City of Albuquerque

November 28, 1988

RE: DRAINAGE REPORT SUBMITTAL OF BARELAS COURT TOWNHOUSES, RECEIVED
NOVEMBER 7, 1988, FOR PRELIMINARY PLAT AND SITE DEVELOPMENT
PLAN APPROVALS. (K-14/D42)

DRAINAGE REPORT EXHIBIT I

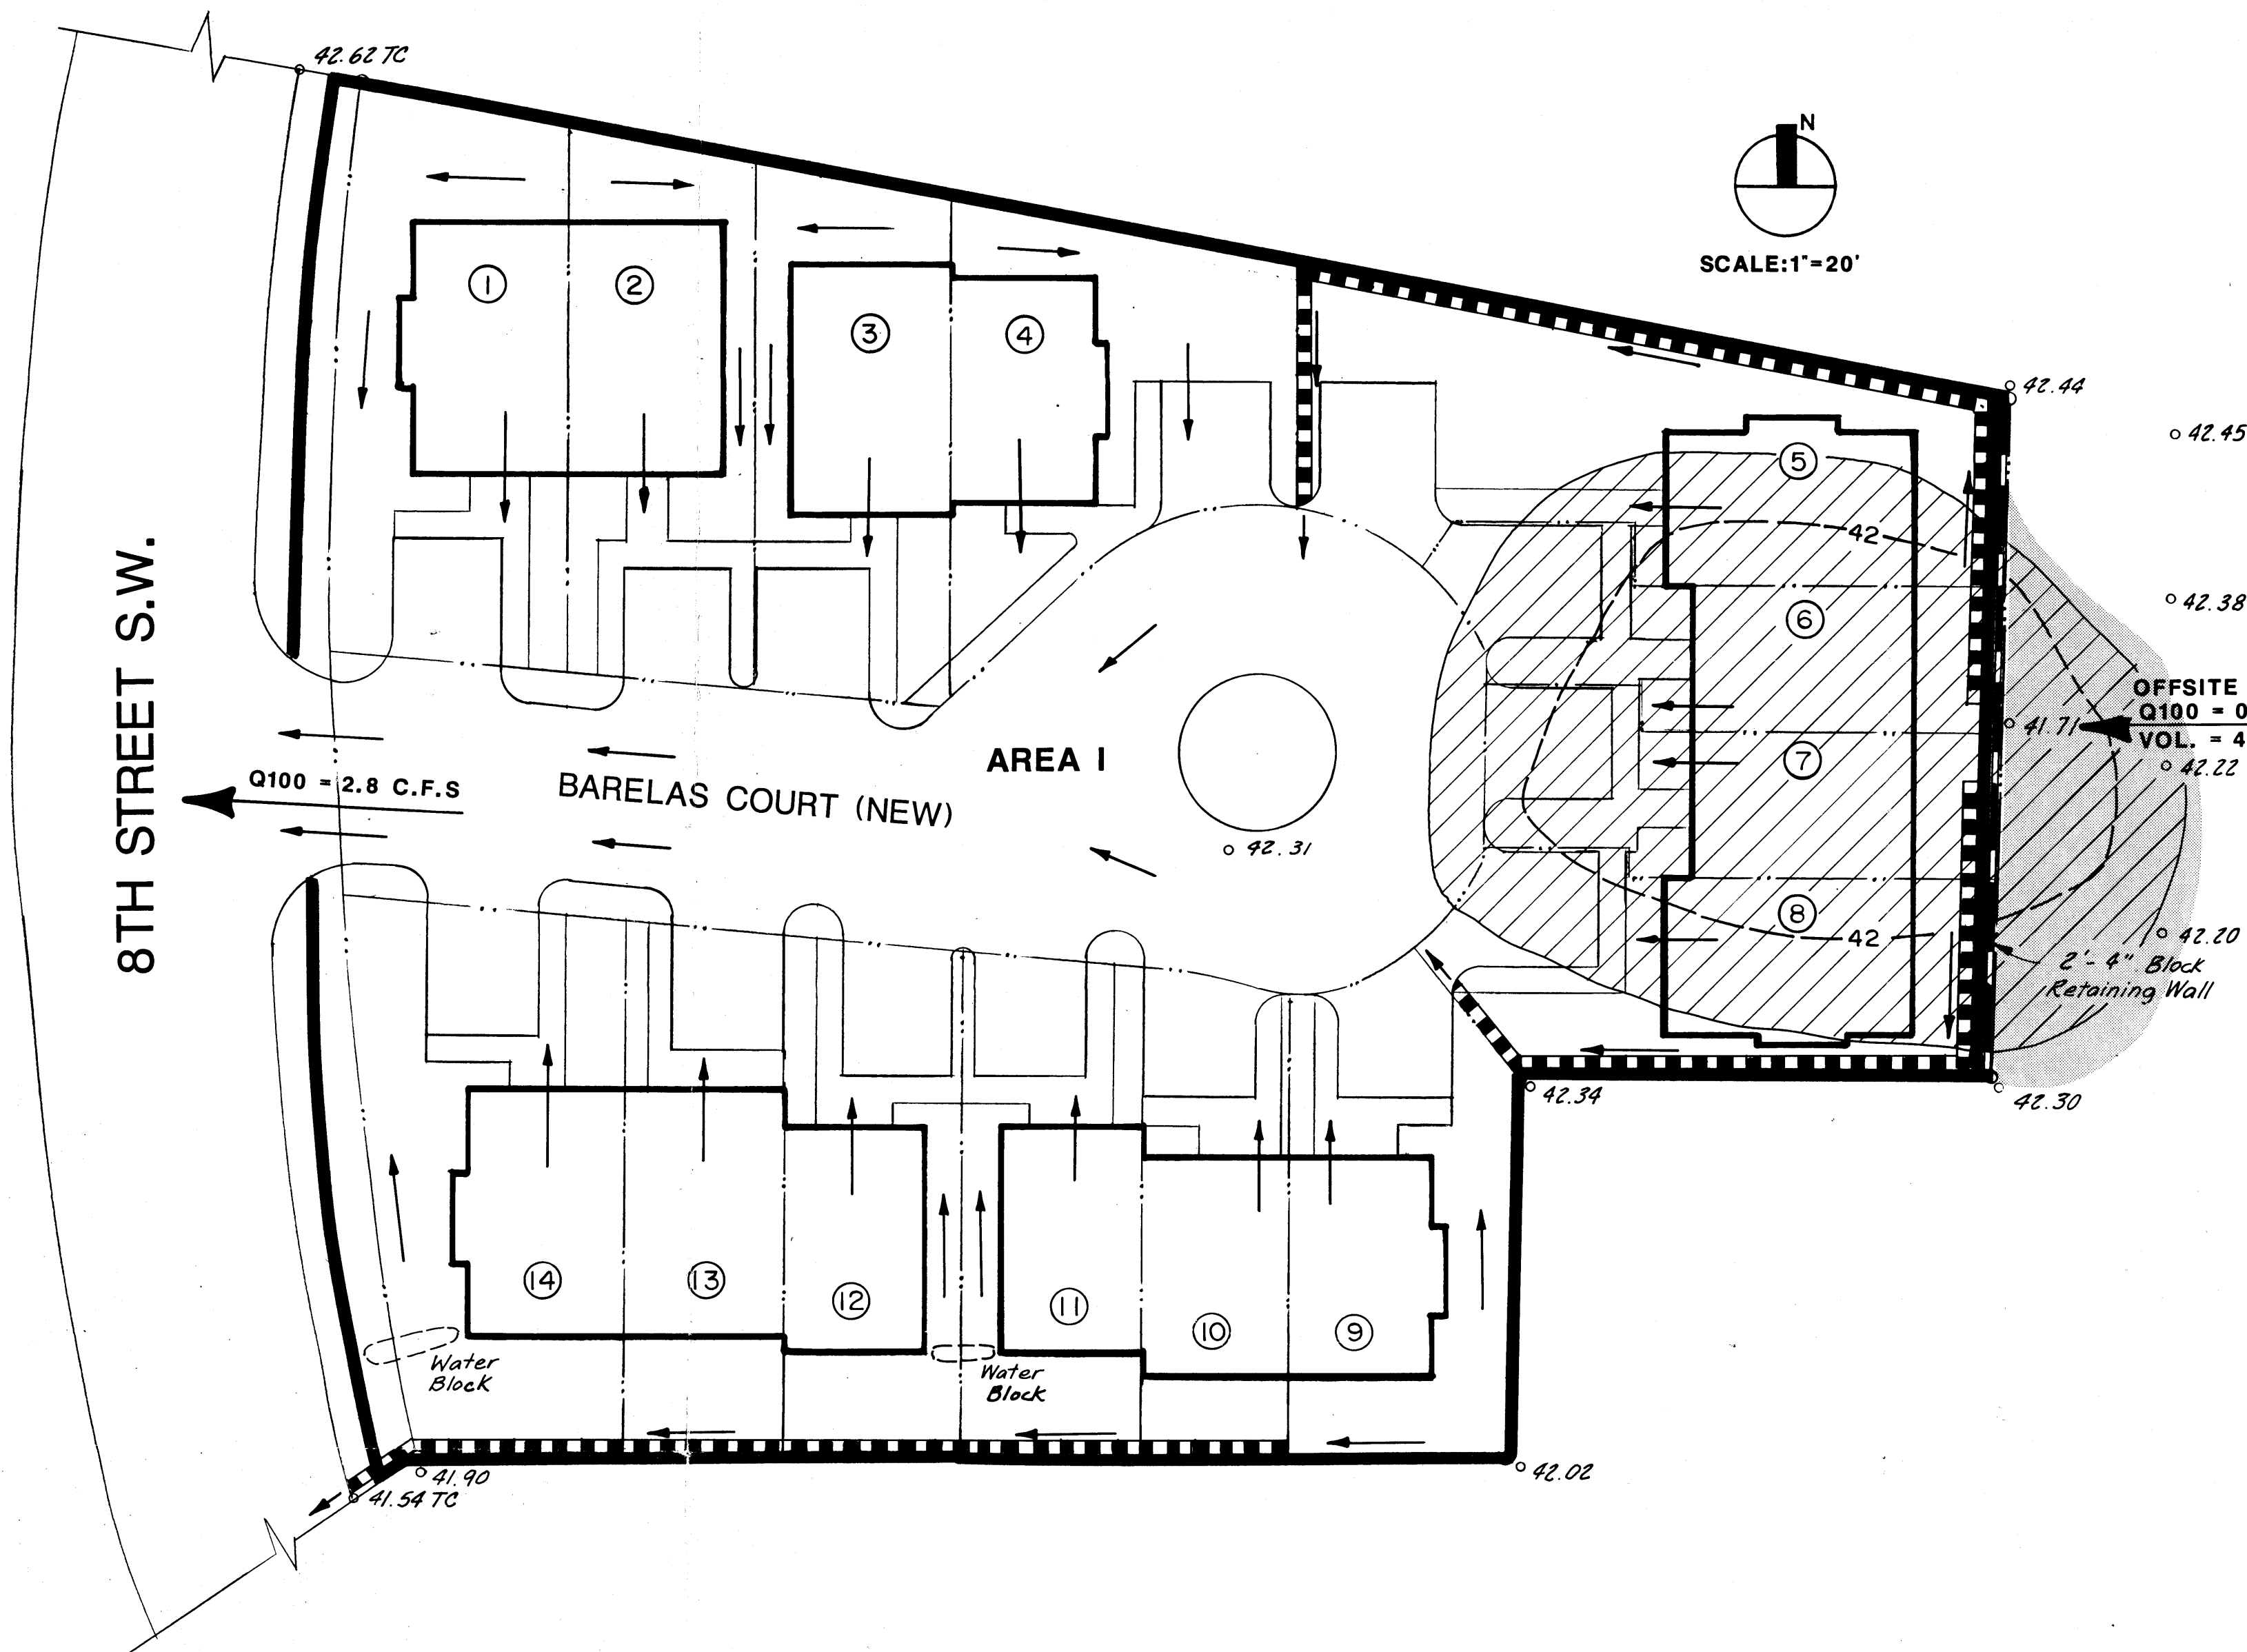
1. The rear yards for lots 6, 7, 10, & 13 must be provided an outfall for surface drainage, either between the buildings or with drainage easements across adjacent lots. For lots 5 thru 8 I recommend providing space between lots 5 & 6 and 7 & 8, or else provide drainage easements and concrete gutters around the corners. For lots 9 thru 14, I recommend that drainage easements be provided along the south property line with a concrete gutter built along the rear lot line sloping east to west, and direct the runoff into 8th Street through a sidewalk culvert.
2. Provide the existing condition hydrology for the area draining to the low spot prior to it's backfilling.
